CELBRIDGE HAZELHATCH MOBILITY CORRIDOR

Responses to Submissions on Section 177AE Consent Application

MDT0902-RPS-00-XX-SH-Z-1001

11th February 2026

Status: A1

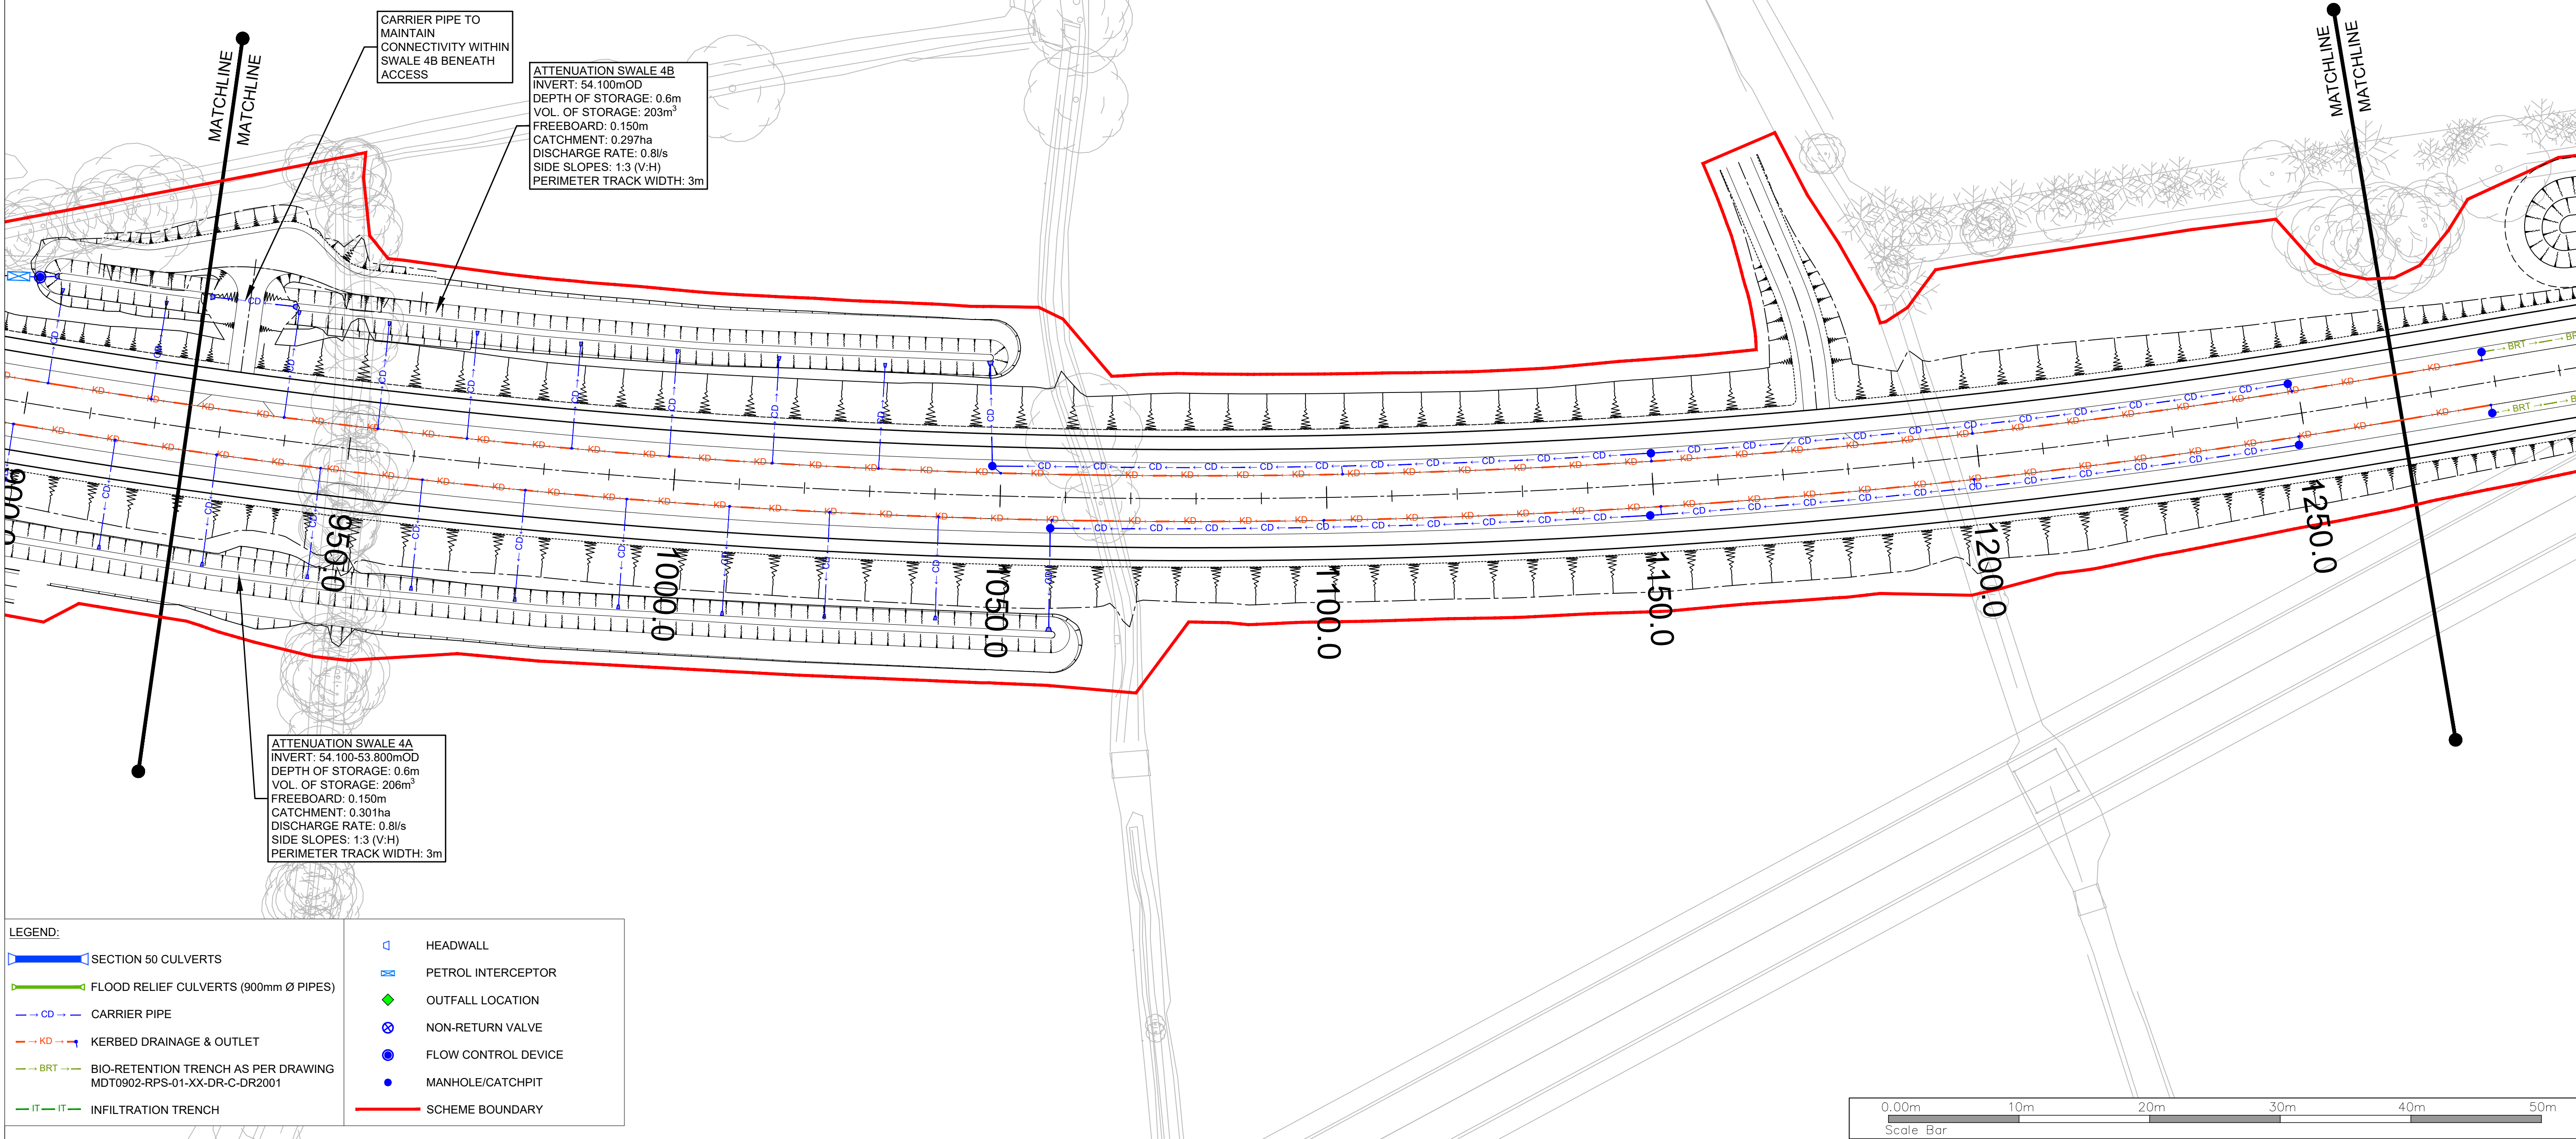
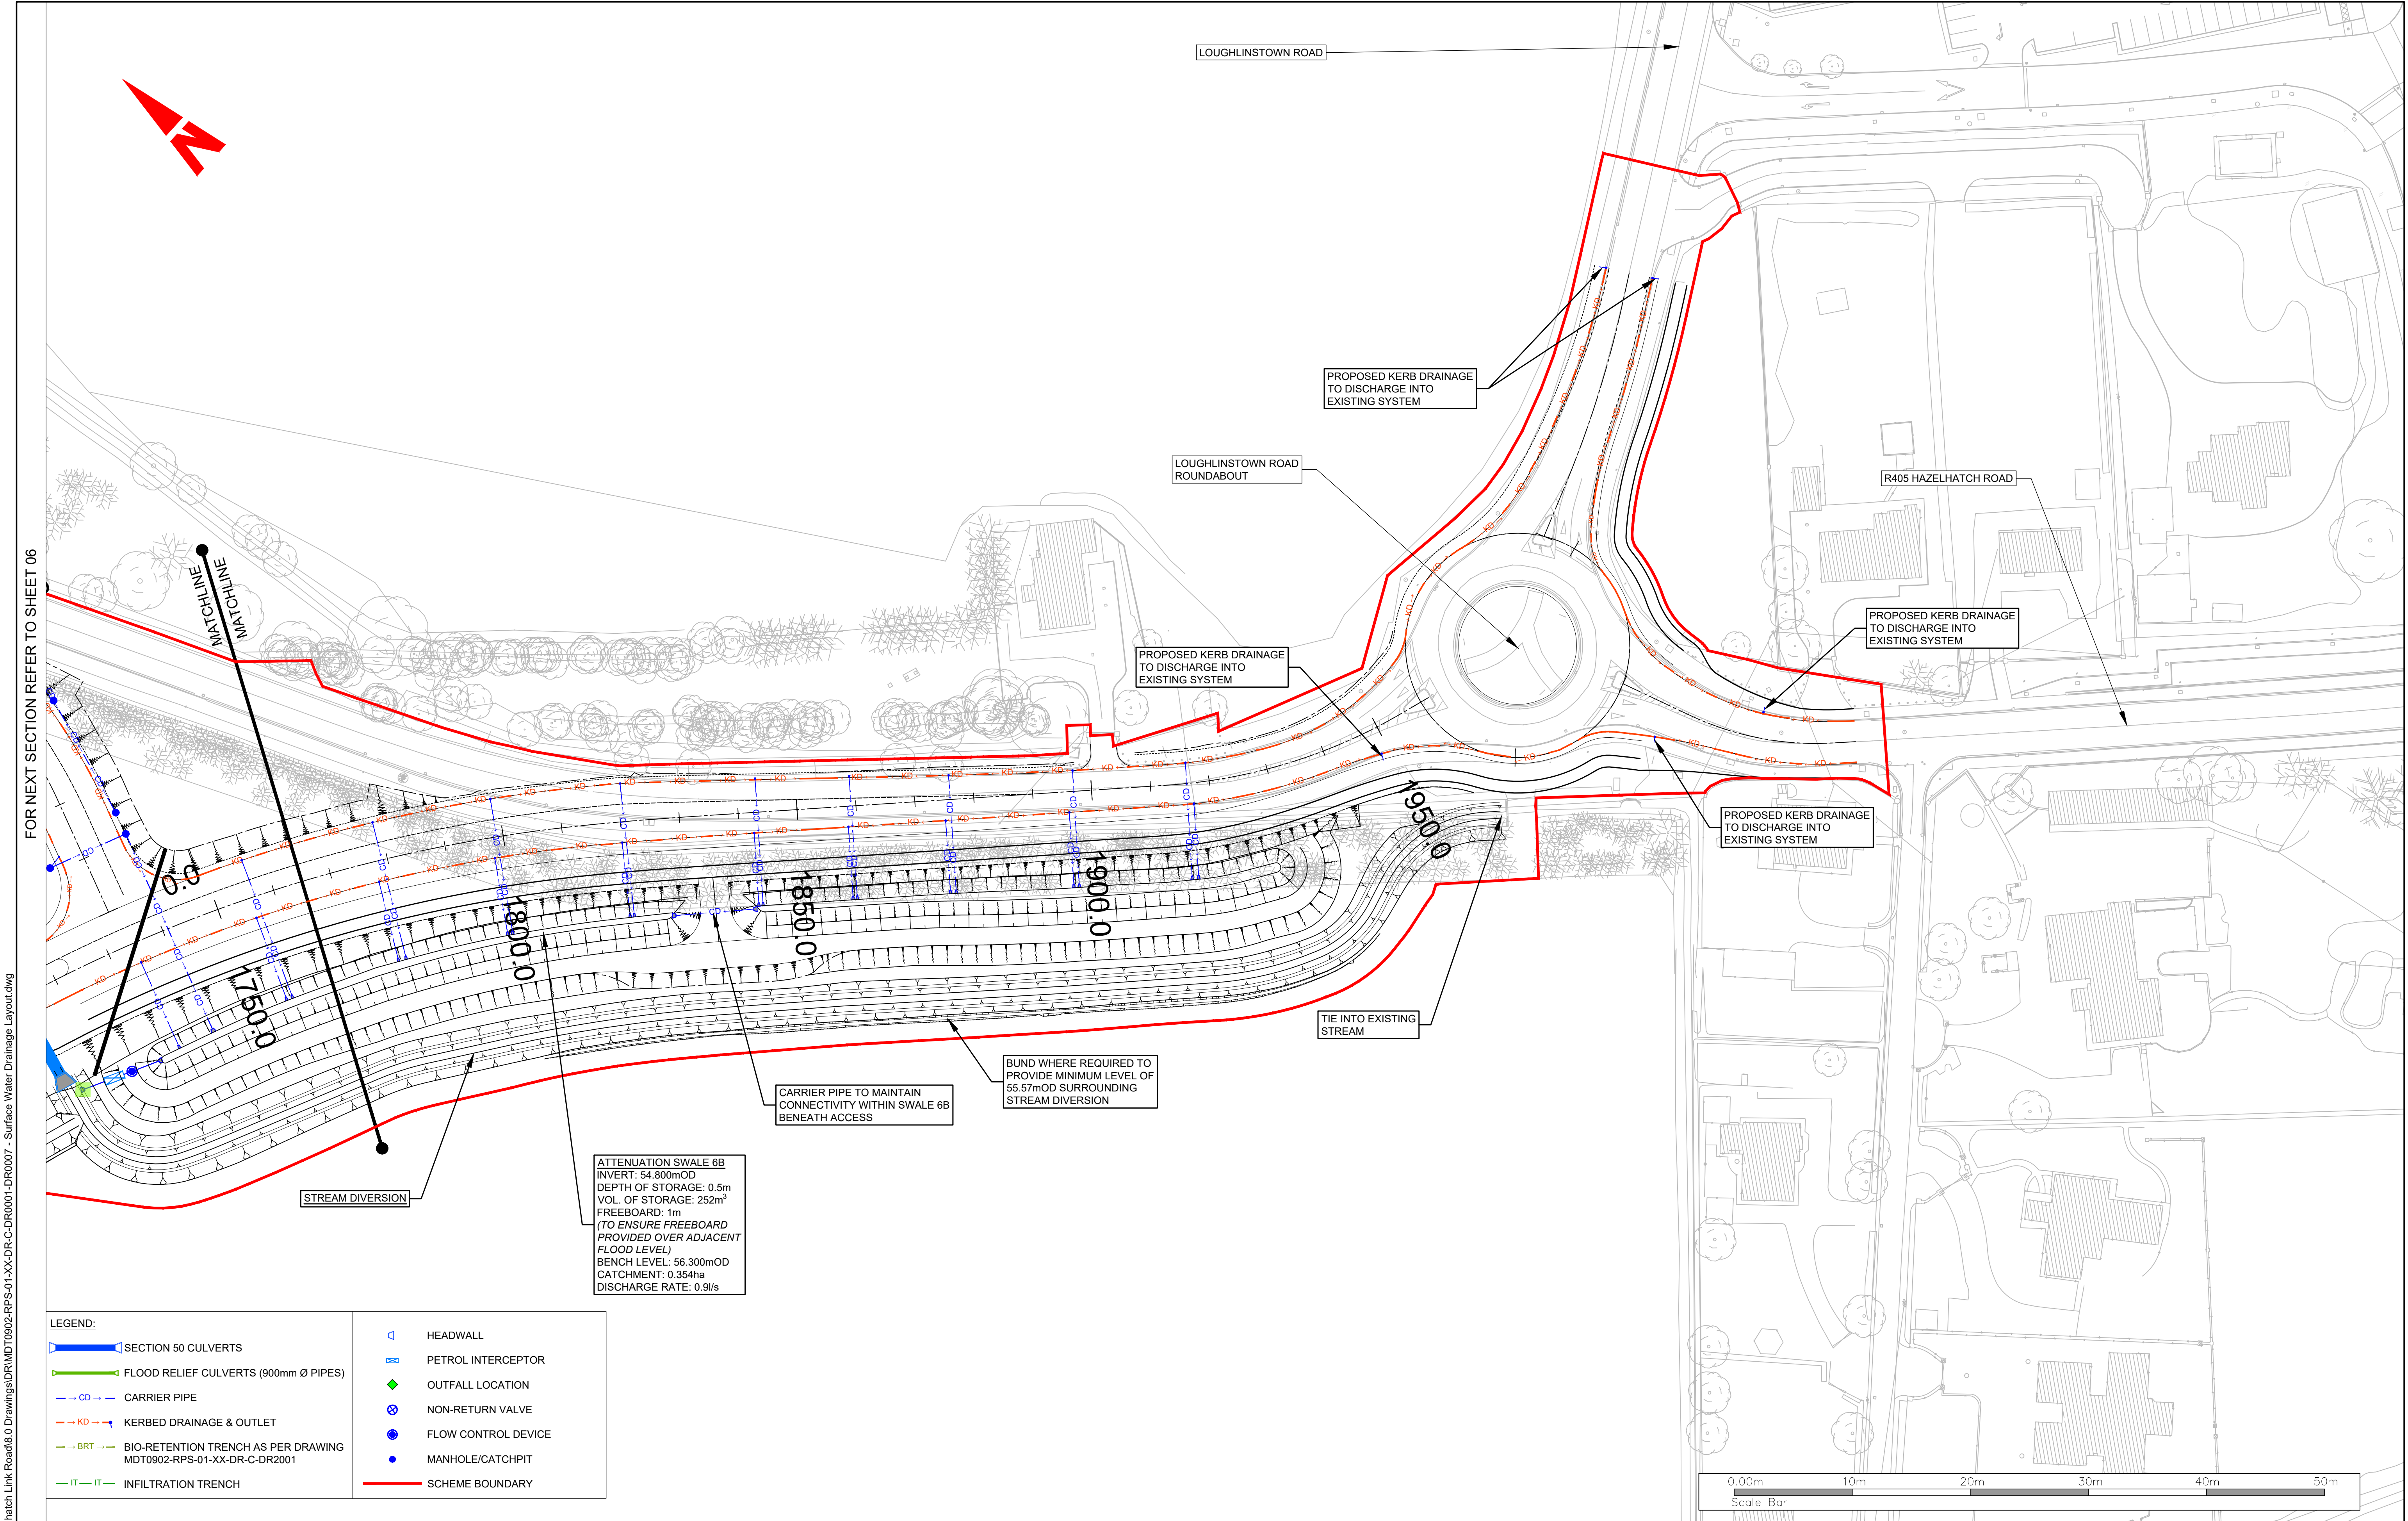
12.	All discharges must follow the European Communities (Surface Water) Regulations 2009 and the European Communities (Groundwater) Regulations 2010.	The proposed surface water drainage layout for the proposed development is illustrated on drawings MDT0902-RPS-01-XX-DR-C-DR0000-DR0007. Various SuDS features are incorporated into the design of the proposed development to reduce operational phase pollutant run-off into watercourses and pollutant infiltration into groundwater in accordance with the European Communities (Surface Water) Regulations 2009 and the European Communities (Groundwater) Regulations 2010 and approval is sought on this basis and subject to such further Conditions as may be imposed by the Competent Authority.
